DECISION DELEGATED TO HEAD OF PLANNING

Application No: H16-0265-24 **Applicant:** Mrs K Cusack

Proposal: Removal of existing flat roofed building including new redefined rear boundary and erection of 3 houses with associated car parking

Location: Rear Of 76 Commercial Road Spalding Lincolnshire

Appendix - Site Maps & Plans
Description
Proposed block plan
Sources
Julian Warrick Architectural Design Consultant

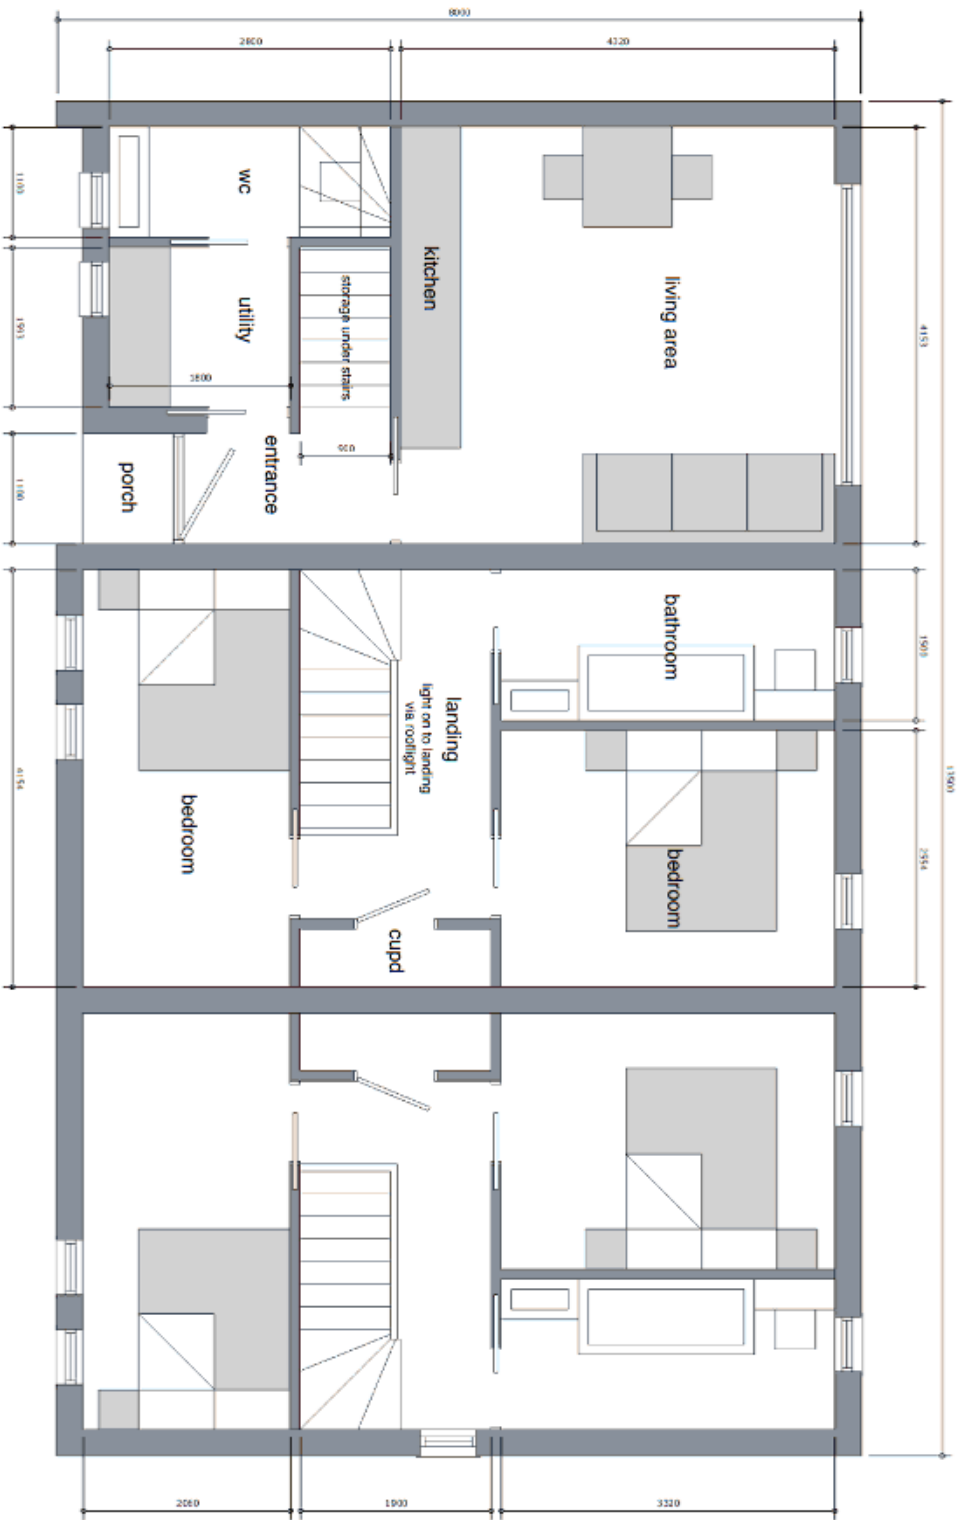
1 parking spaces is detailed for each dwelling, where does 76A park? Where would visitors park? A swept path drawing is required showing how all calling vehicles will turn within the site should all parking spaces be in use.

There are existing garages fronting the access, the block plan needs to show cars parking in front of the garages to ensure access is achievable to the site, detailing the widths available.

Response dated 12 June

No objections.

Appendix - Site Maps & Plans
Description
Proposed floor plans
Sources
Julian Warrick Architectural Design Consultant

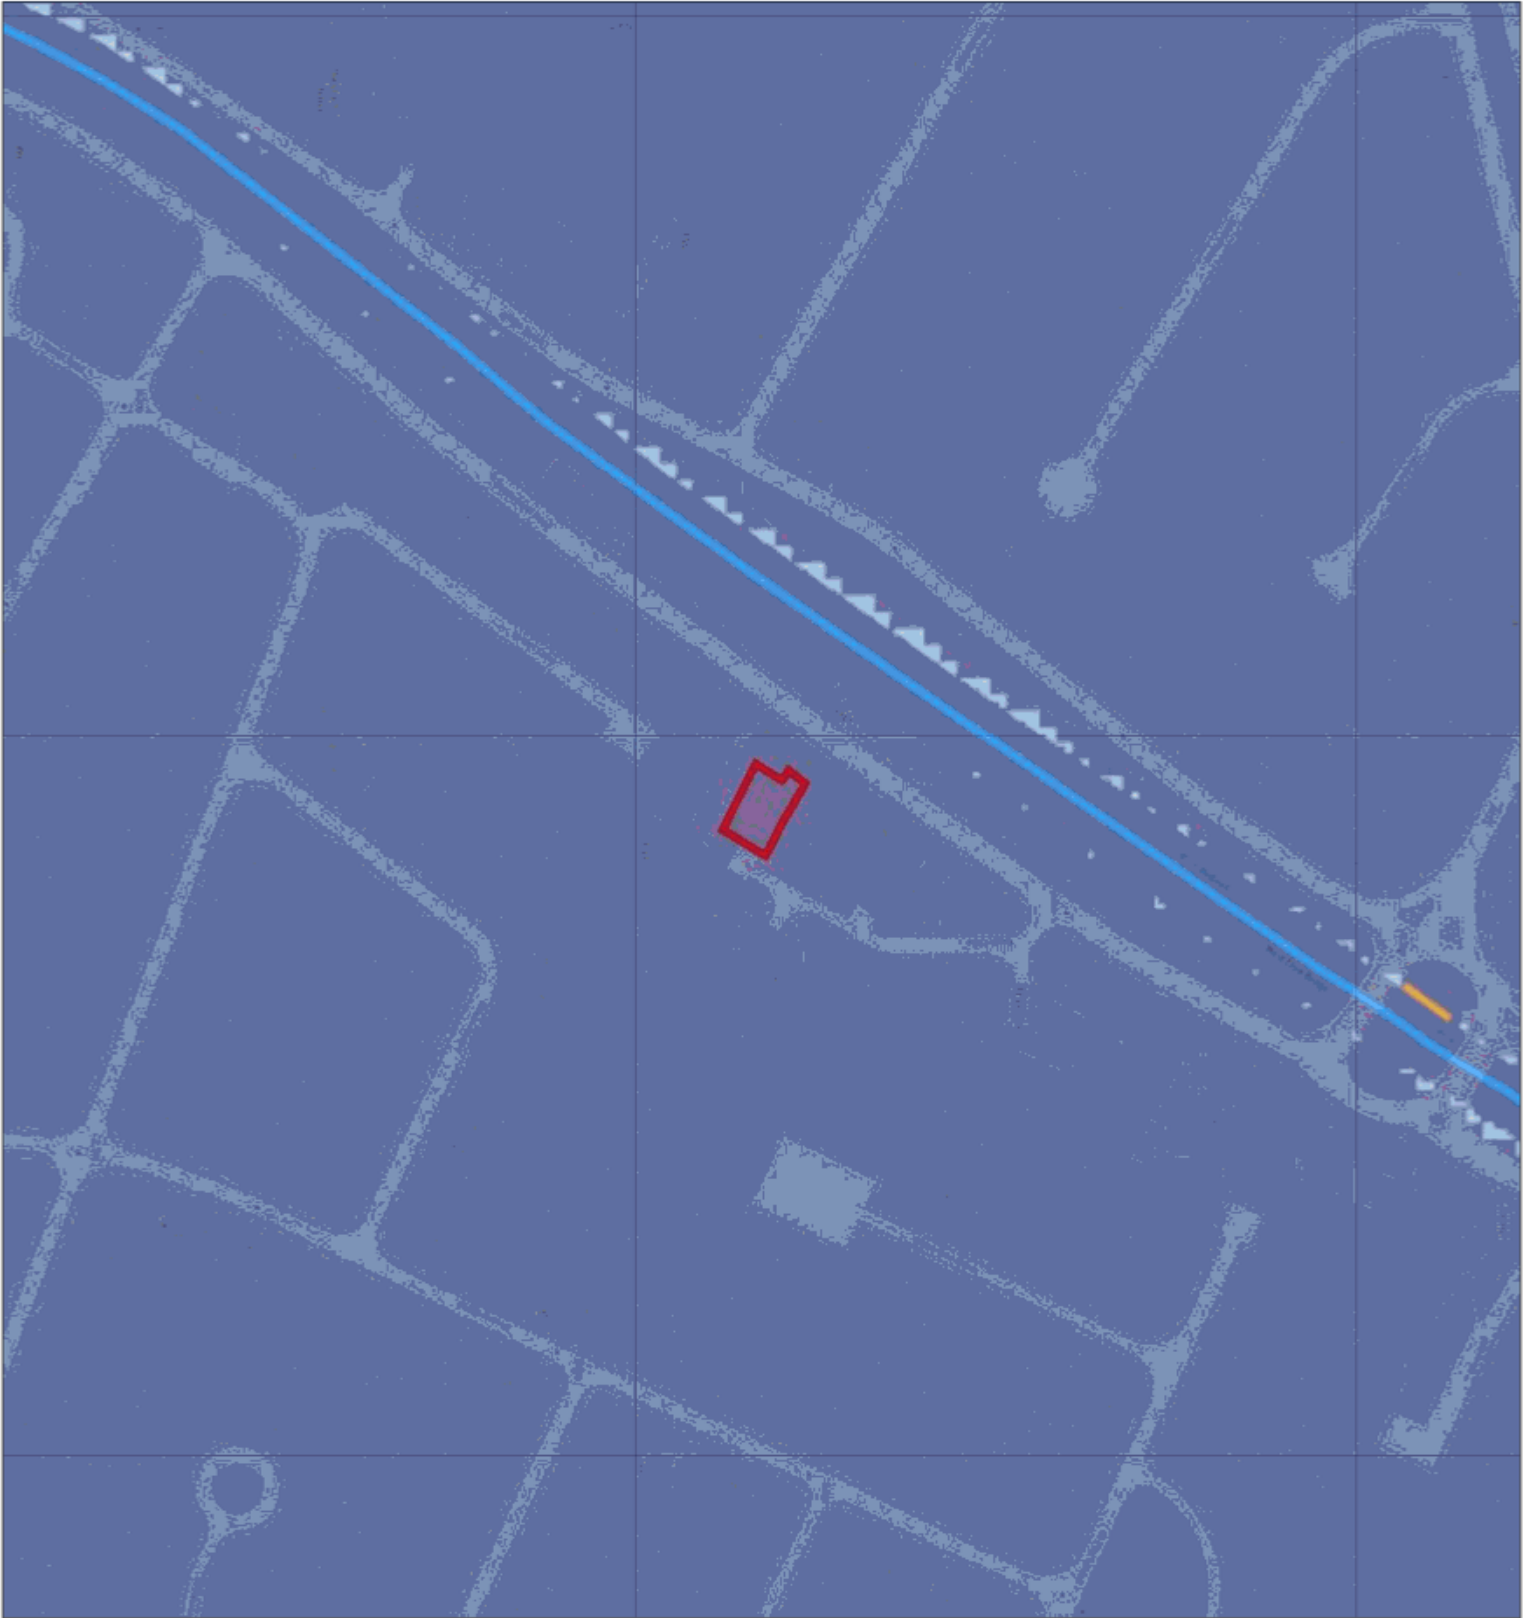
The proposals represent the introduction of three dwellings over garages in the rear garden of 76 Commercial Road. The dwellings themselves are below the minimum internal floor area of the smallest Nationally Described Minimum Space Standards, at 33 square metres, with the smallest one bedroom one person dwelling for the latter standards should be 37 square metres, with a shower instead of a bath. The dwellings would be very small, set within the amenity space of number 76. No amenity space would be available as the entire rear amenity space, would be taken up by hard surfacing to facilitate parking for number 76/76A and parking and manouvering space for the garages beneath the flats.

The flat roof design is out of keeping with the character of the area, which although is varied, all residential properties have pitched, tiled roofs. It is considered that the design is out of keeping and
